Your Ref:
Our Ref: FP/173/08/
Please ask for:
Mrs S Leeson

Minor alteration to change roof detail over main entrance doors from hipped to gable detail & installation of new red fabric 4m square jumbrella

The Southdowns 133 Felpham Way Felpham

Thank you for your internet comments made on 29th September 2008 and recorded as follows:

Title
PROPOSED ELEVATIONS, ROOF
PLAN AND SITE PLANS

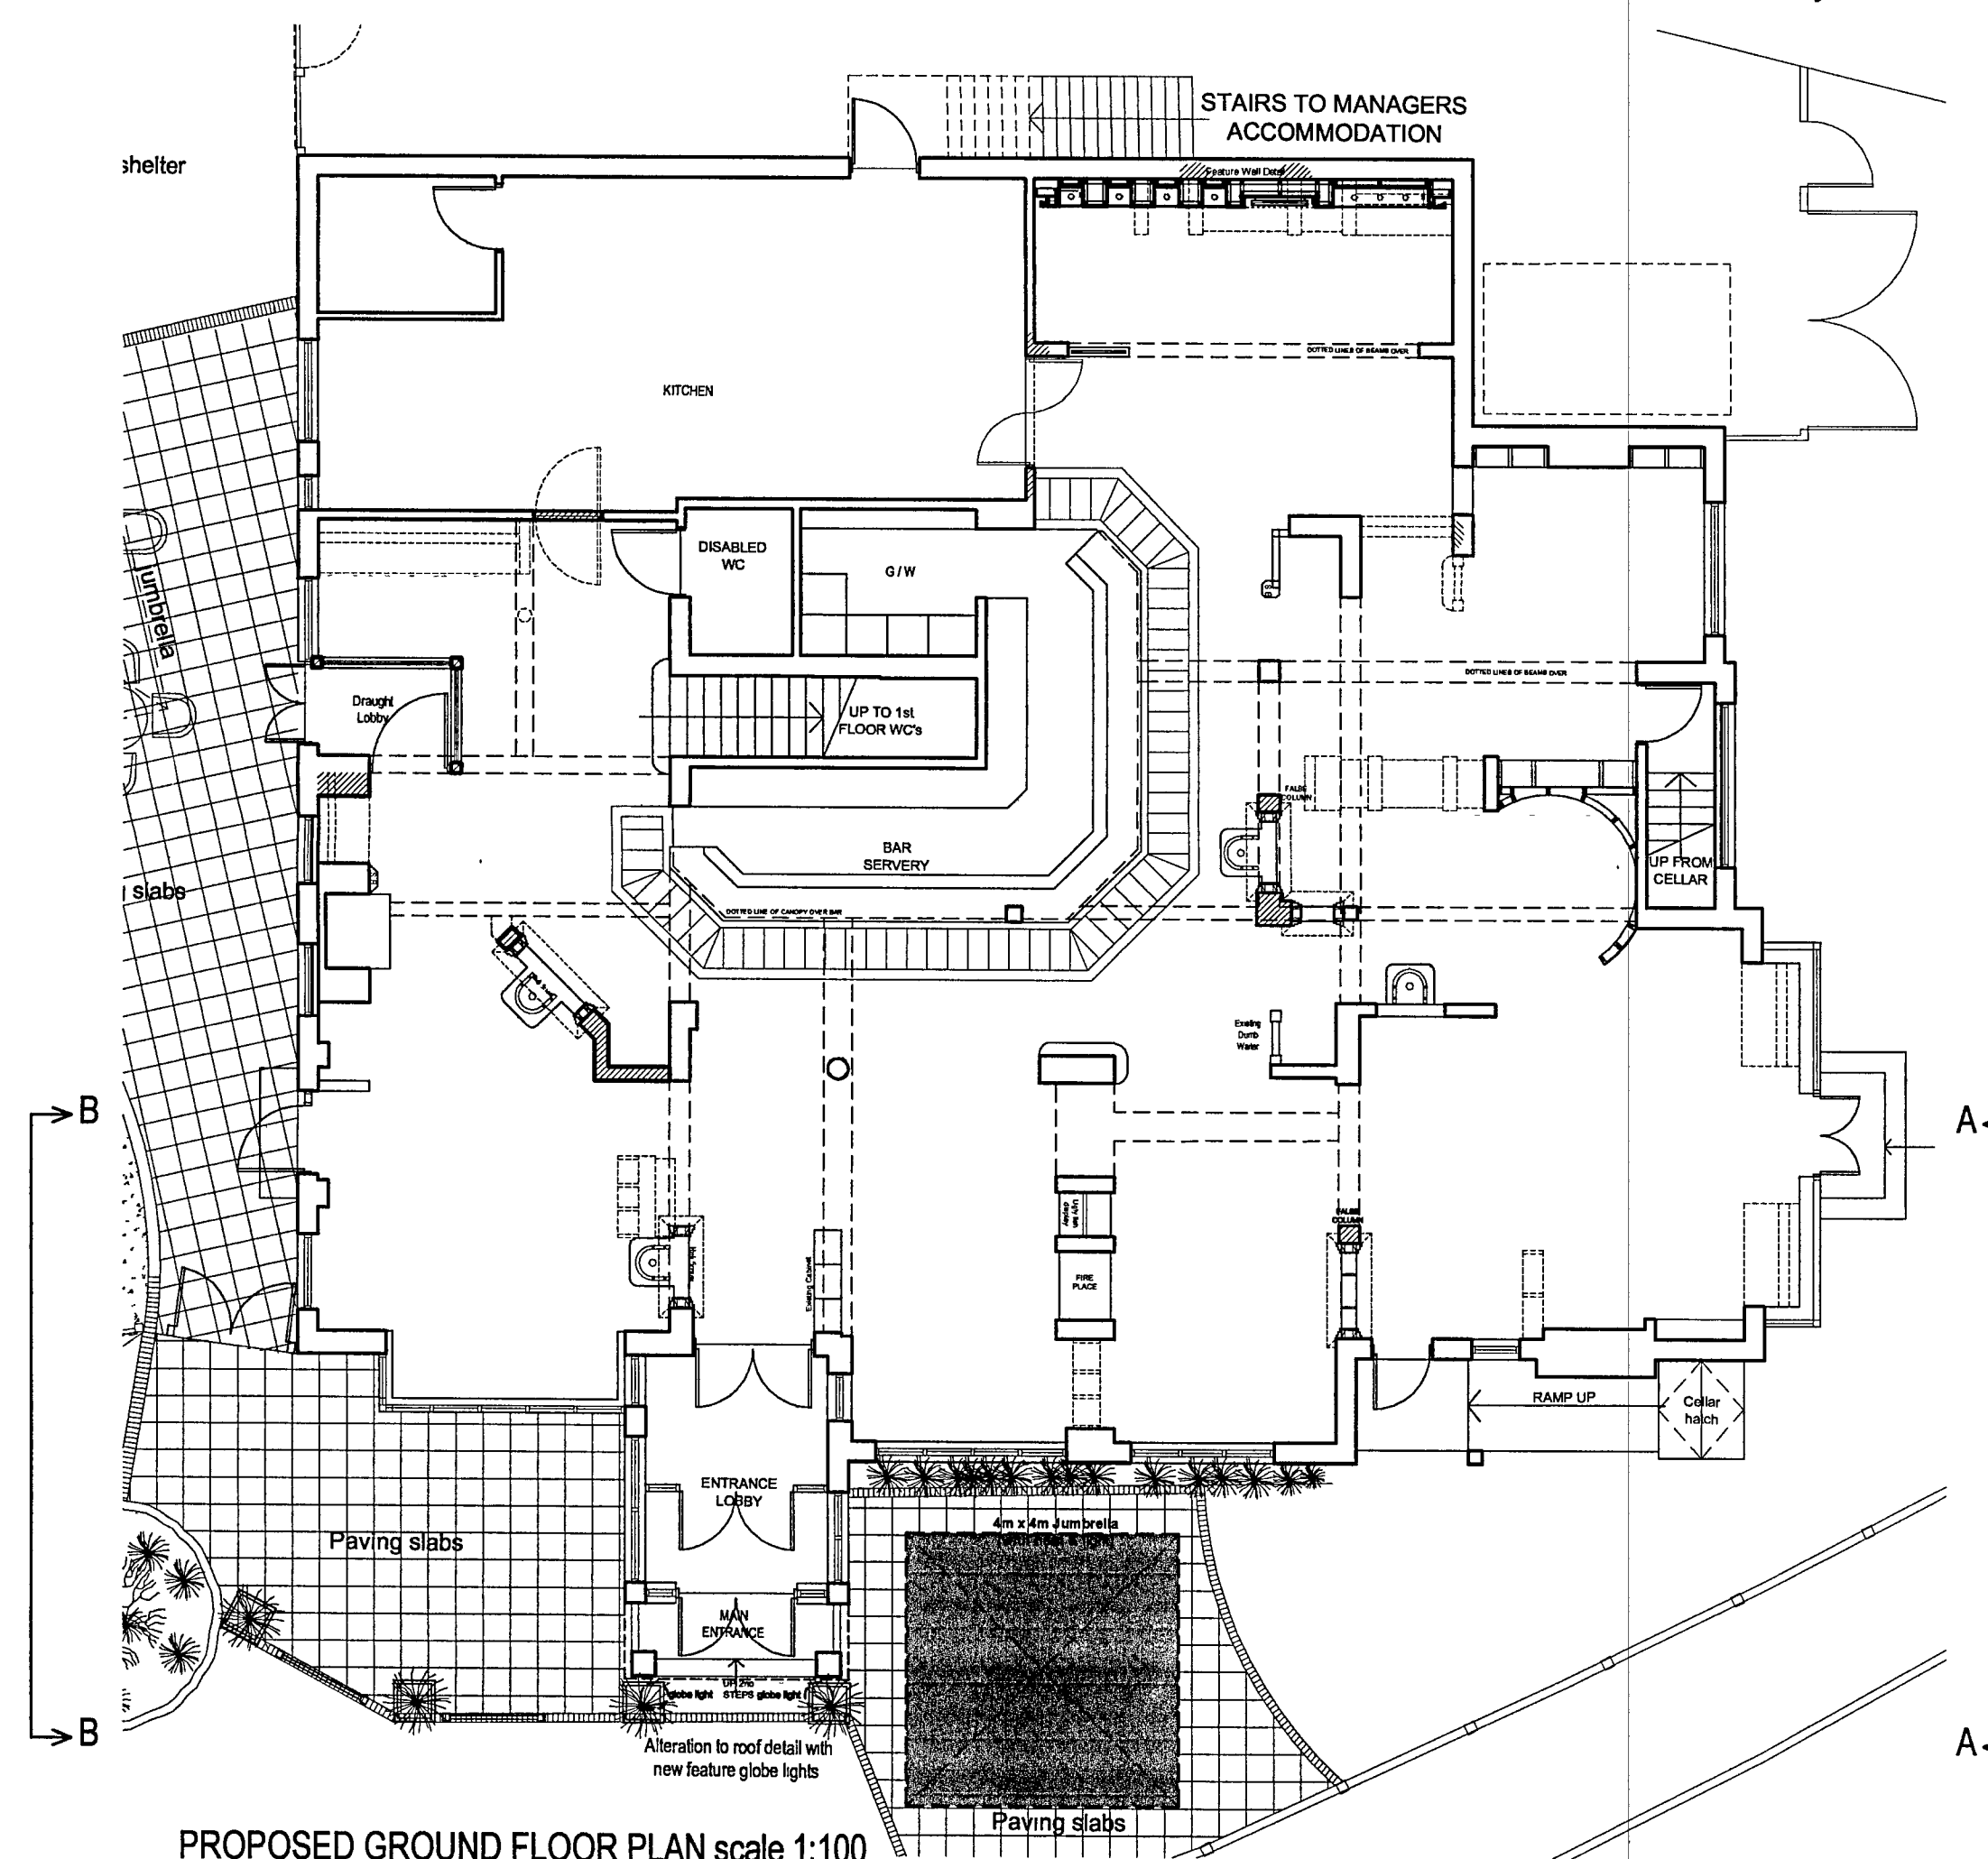
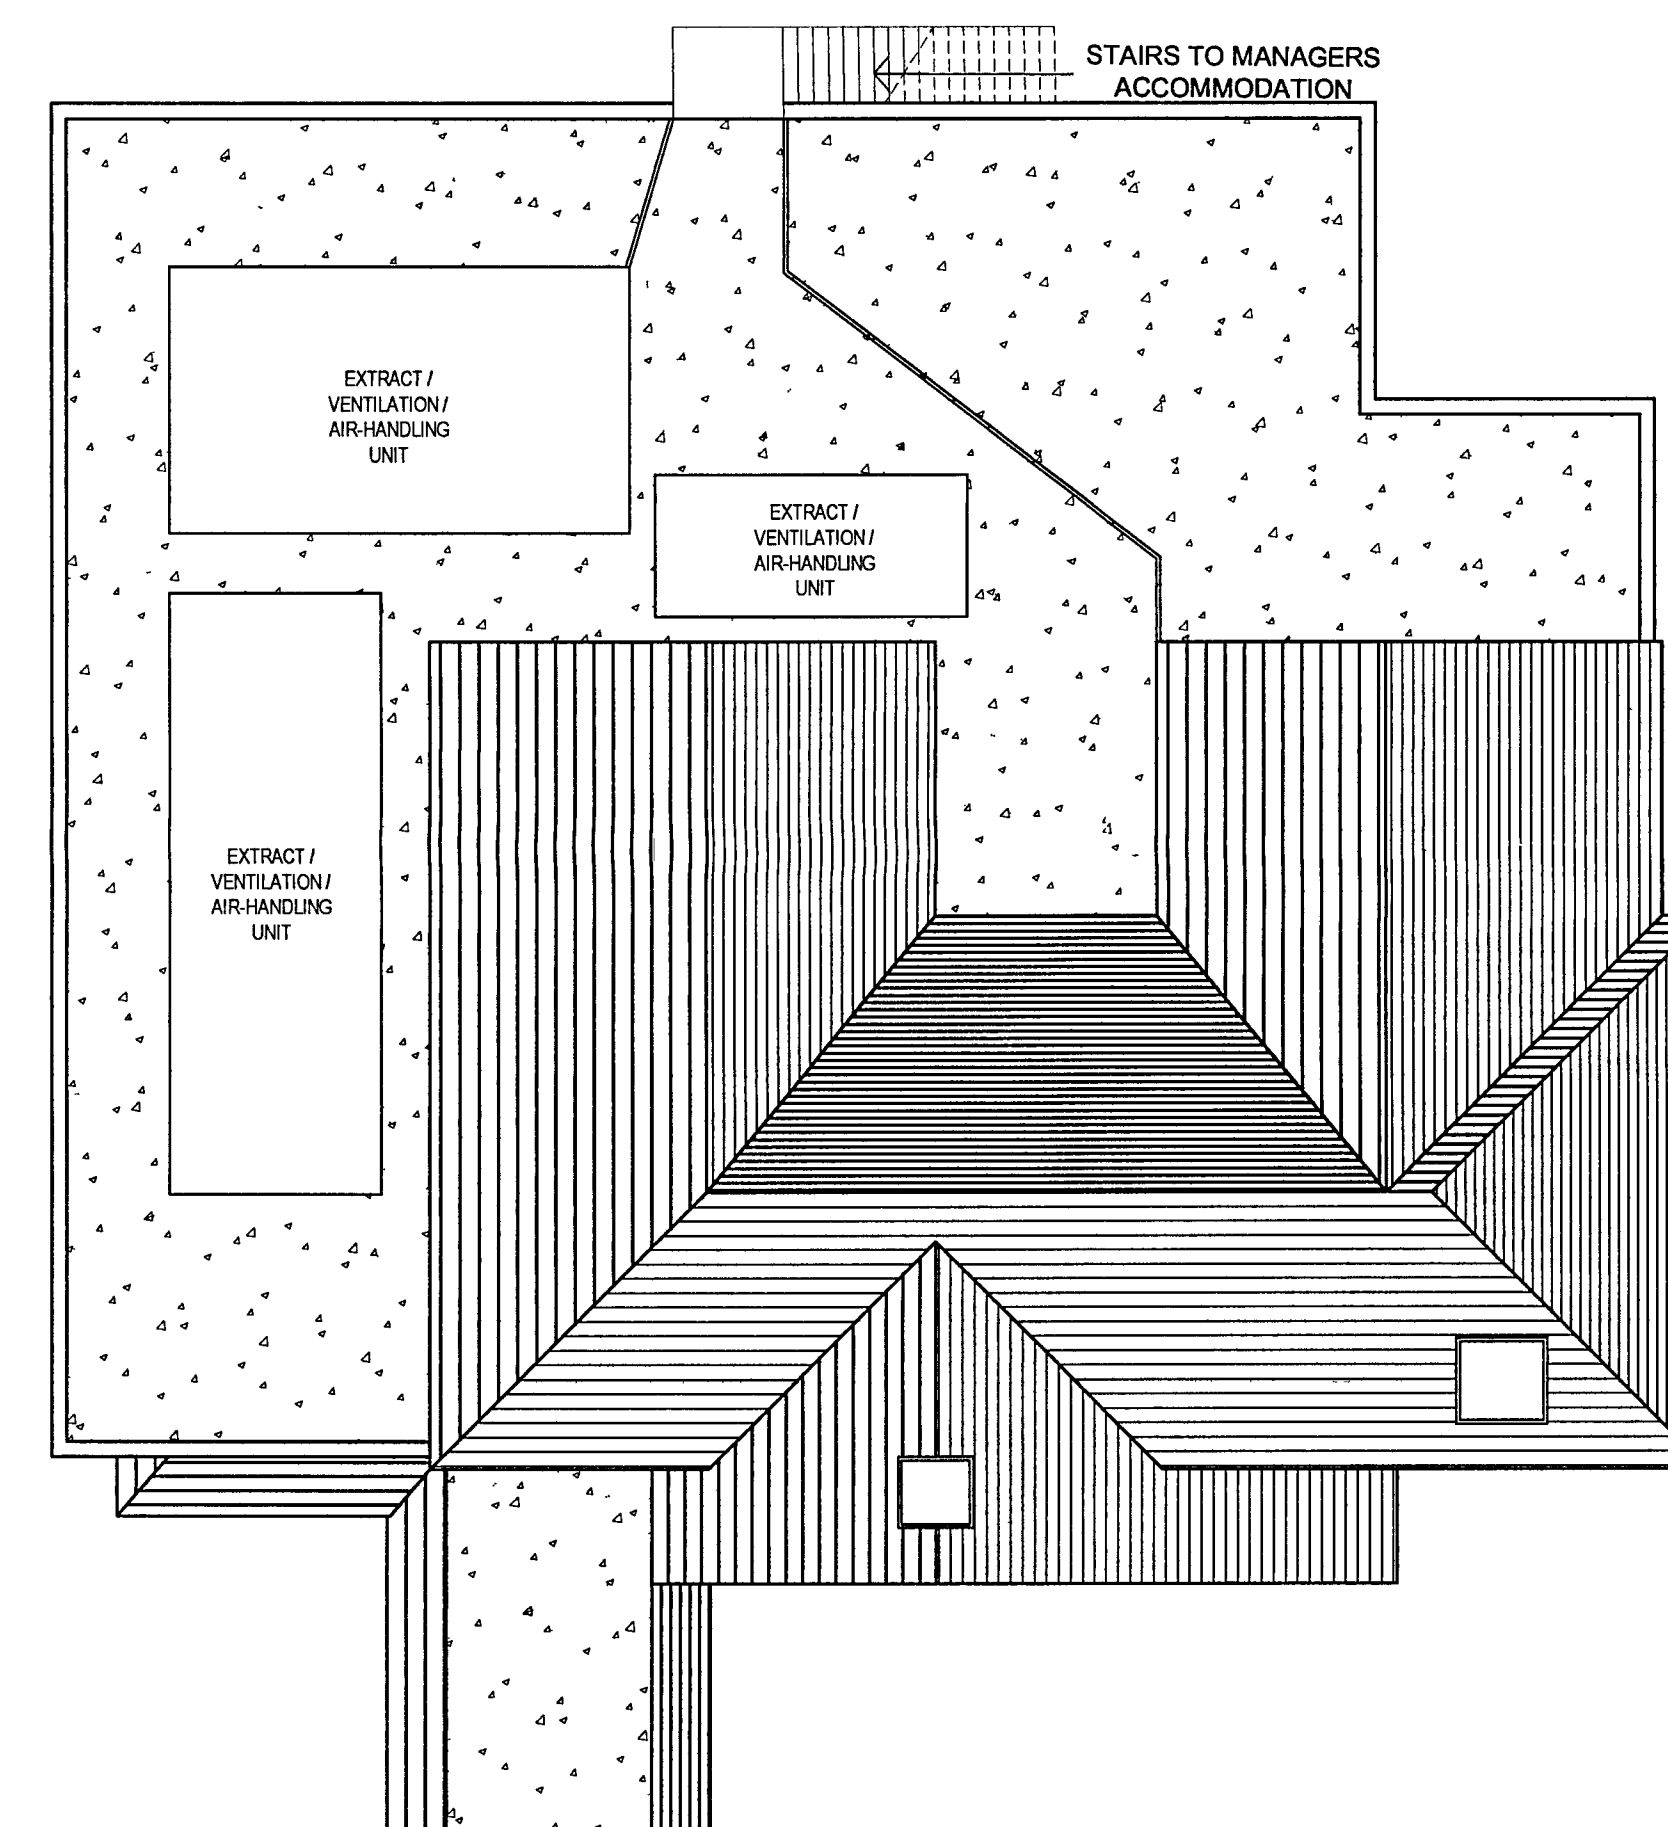
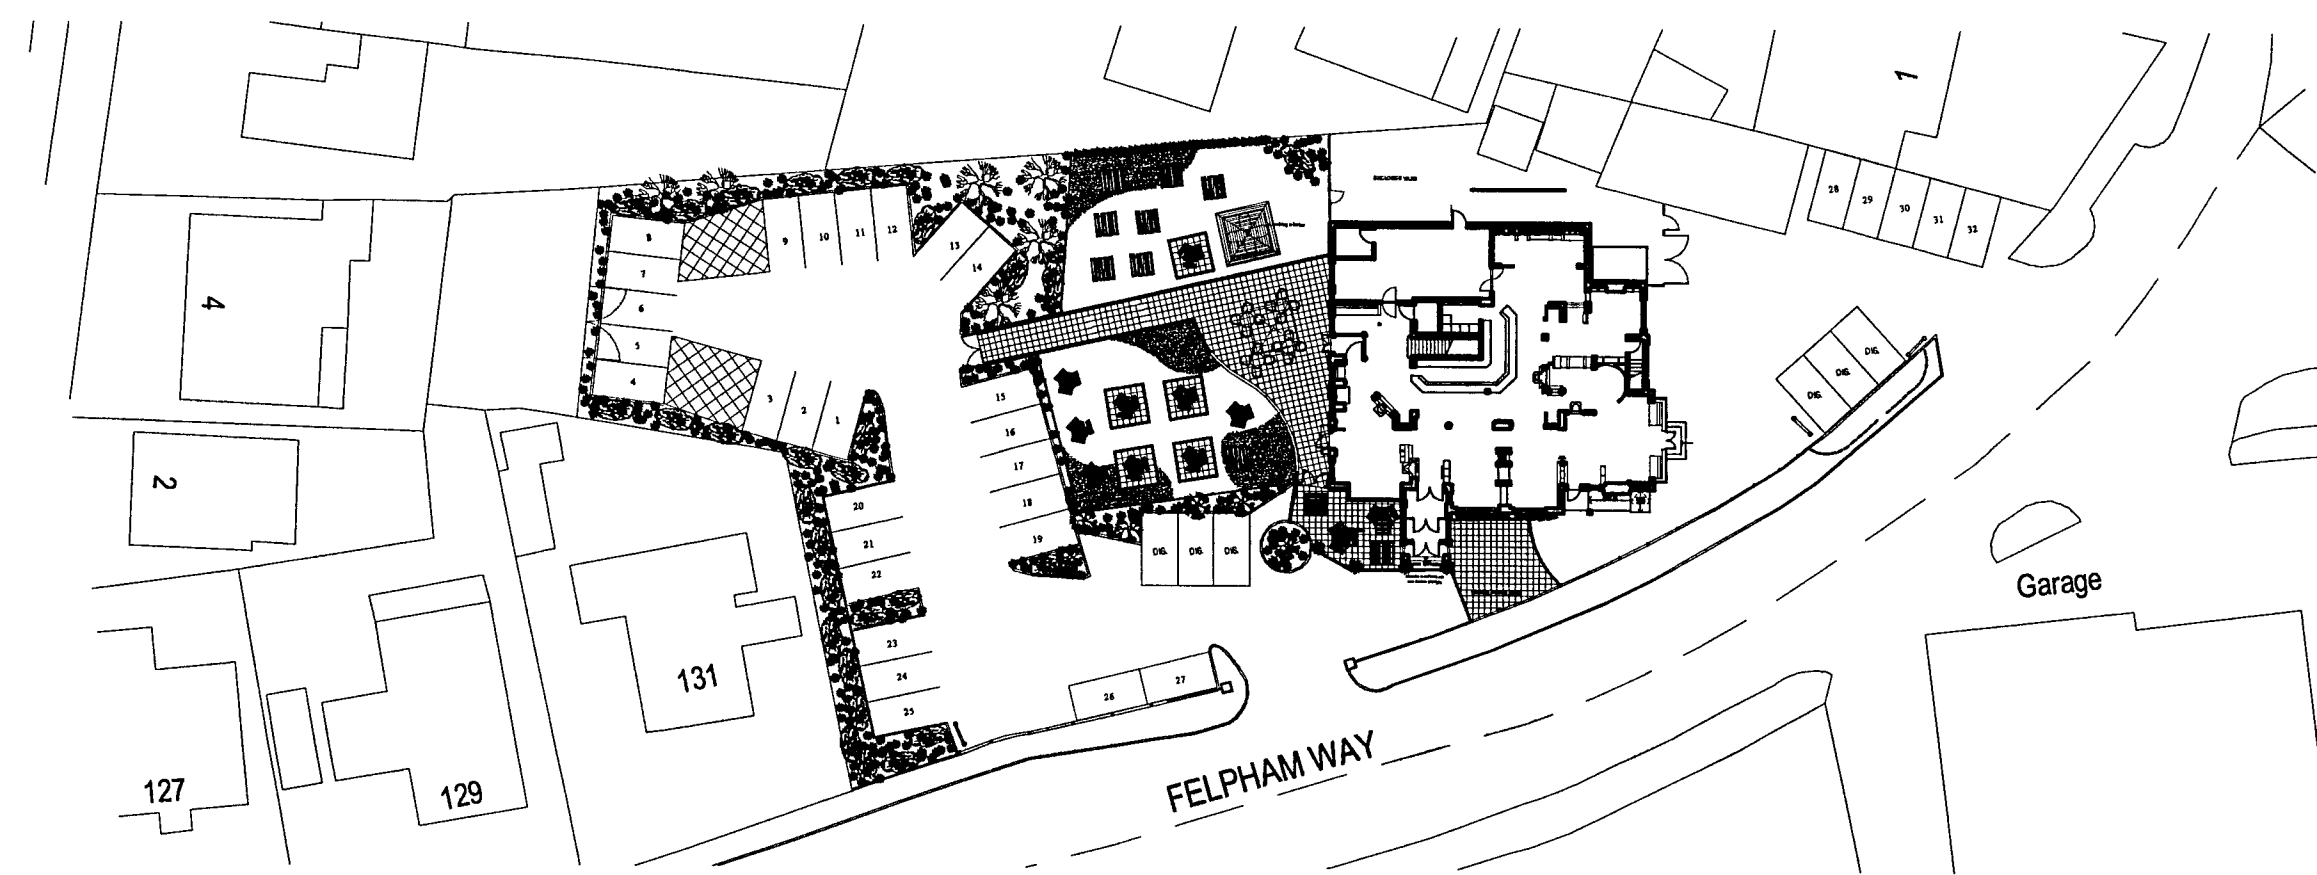
1. *The size and colour of the proposed Jumbarella will affect the visual amenity.*□
2. *The Jumbarella may be distracting to passing traffic where there is a Pelican crossing and a busy roundabout in the immediate vicinity causing a potential safety hazard to both pedestrians and motorists.*□
3. *The proposed site of the Jumbarella for external seating is not appropriate adjacent to such a busy road.*
